Freedom Forever
Planset Revision Letter

5/4/2023
REV #3

ADAM DAVIS
86 DERBY LANE, LILLINGTON, NC 27546

1) Layout change (Ticket #1170618)

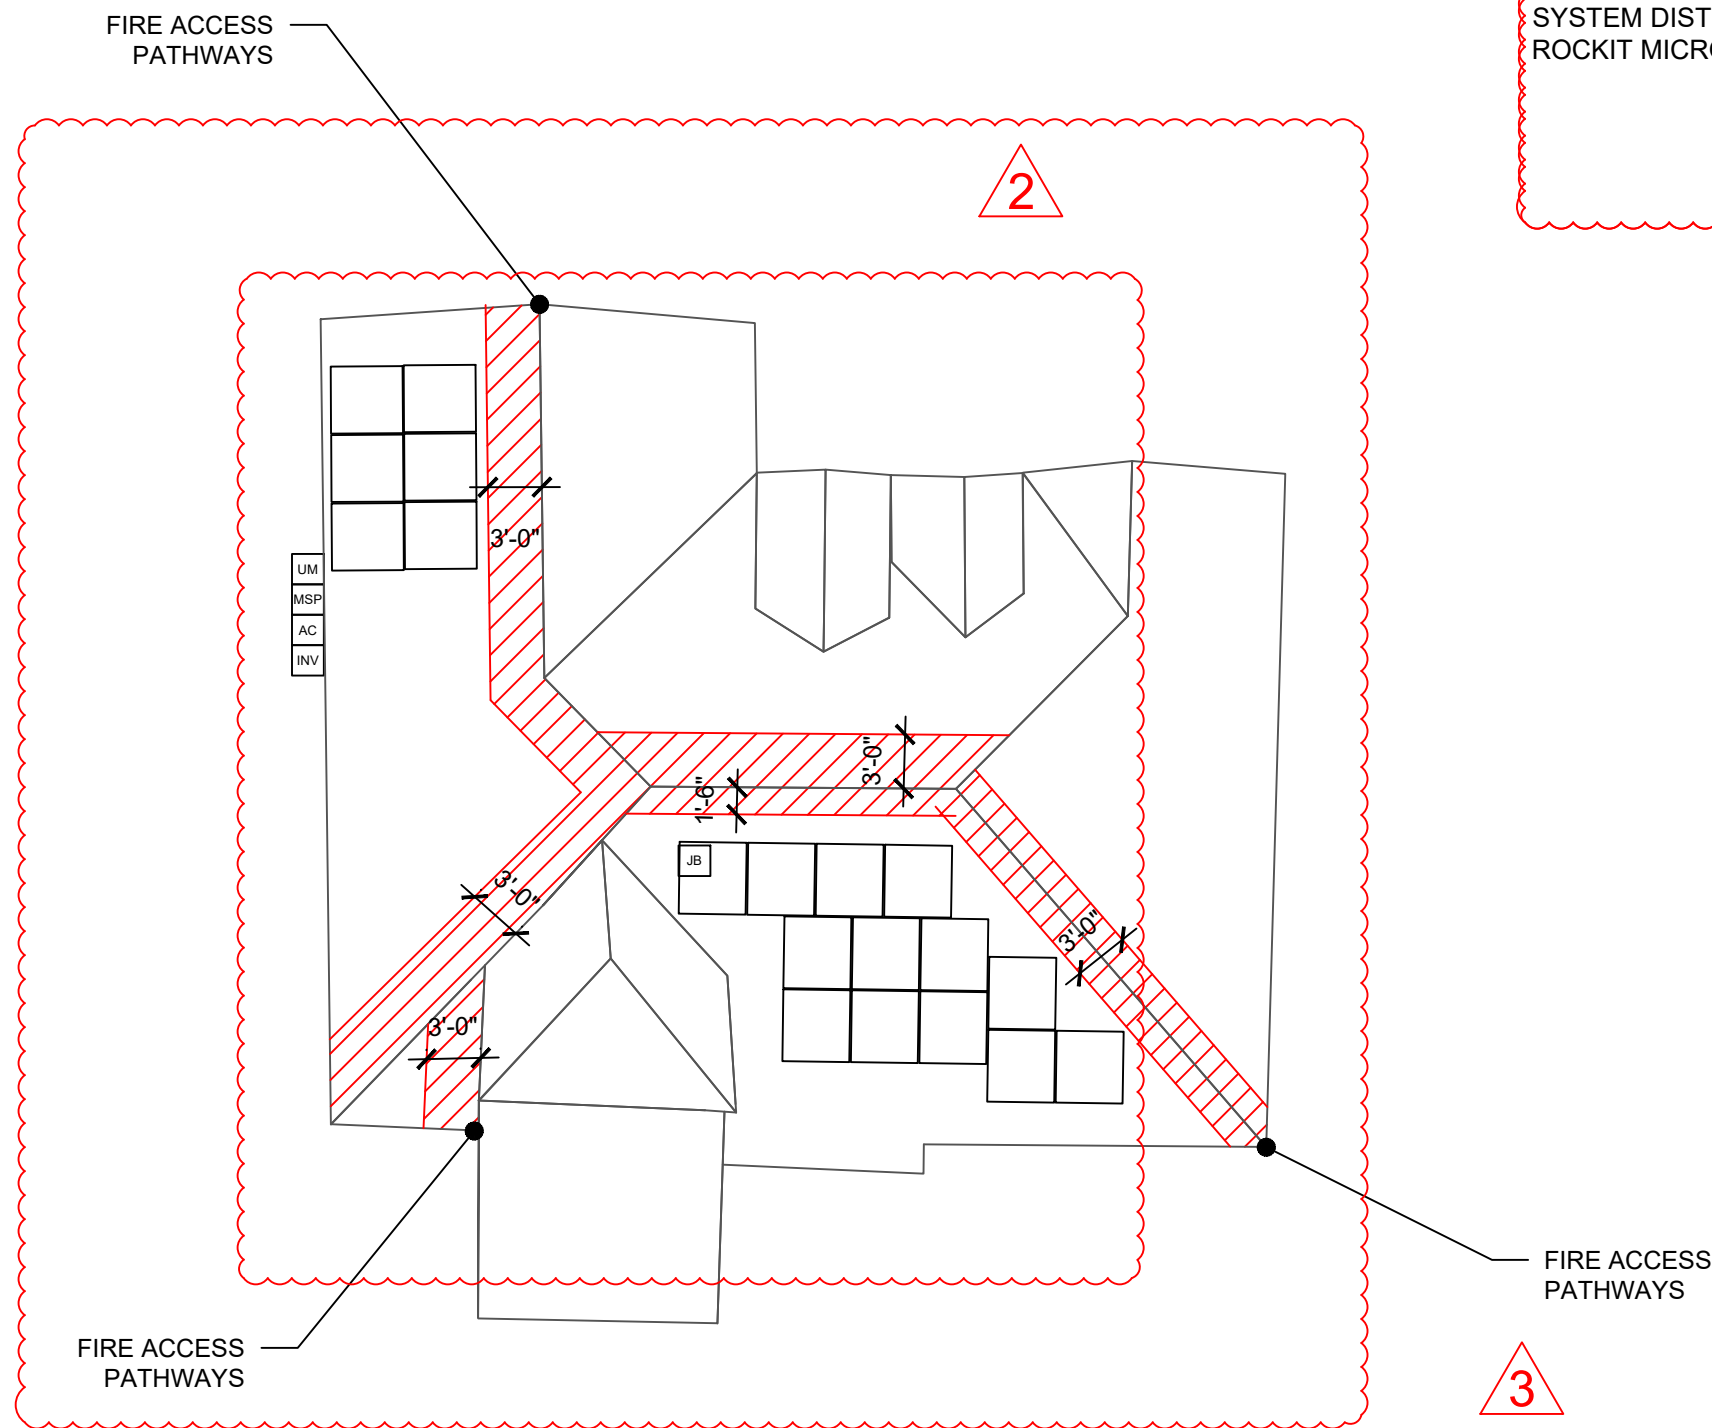
All corresponding changes are notated on the plans by revision clouds.
